**WEST SUSSEX COUNTY COUNCIL
PLANNING SERVICES CONSULTATION**

SUBJECT: AW/155/17/PL - Erection of 1No. detached dwelling. This application affects the character and appearance of Craigweil House Aldwick Conservation area.

28A, Kingsway, Aldwick, West Sussex, PO21 4DH

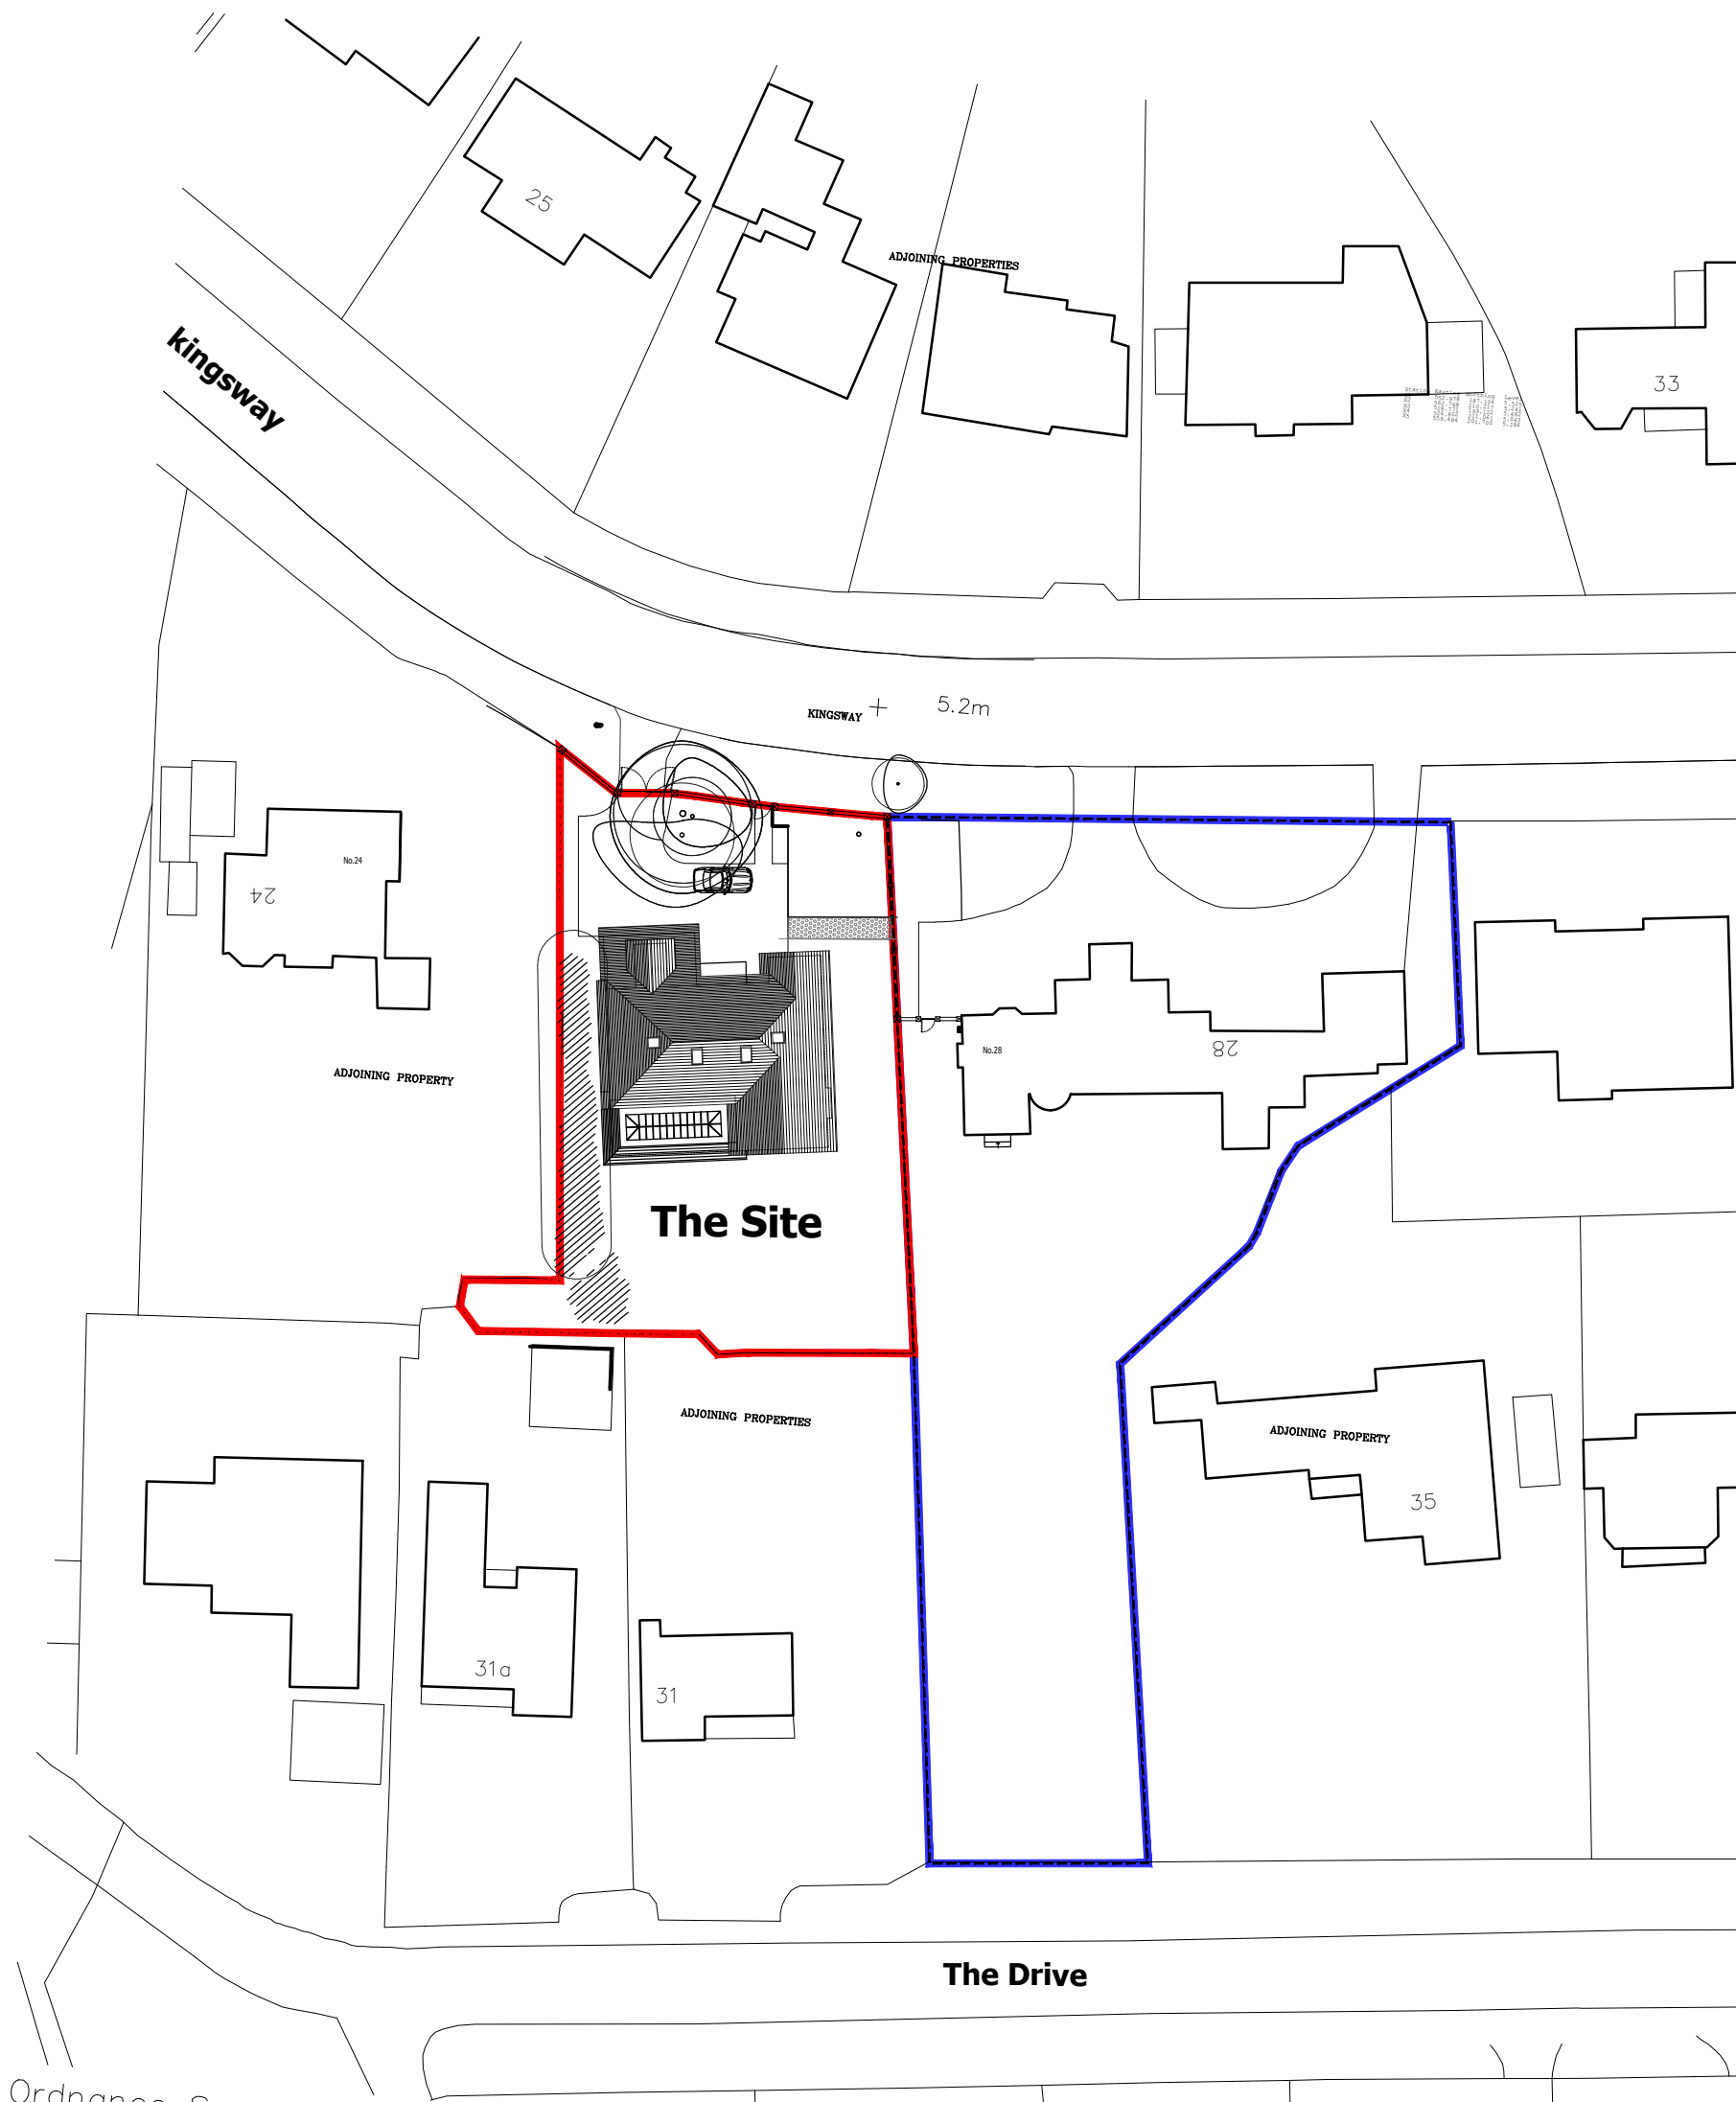
The proposed site layout plan indicates that the proposed site access will be adapted. The applicant would be advised to agree these works with the proprietor of Kingsway. The proposed access scales to 3.5 metres in width which is considered suitable for a single dwelling access.

The proposed site plan shows gates opening outwards of the site. Typically gates should open inwards of the site and be set back a minimum of 5 metres for the carriageway edge to allow a vehicle to be removed from the carriageway while the gates are opened.

The proposed parking and turning facilities would be considered adequate for a dwelling of this size in this location. The dwelling should be provided a secure and covered cycle parking provision.
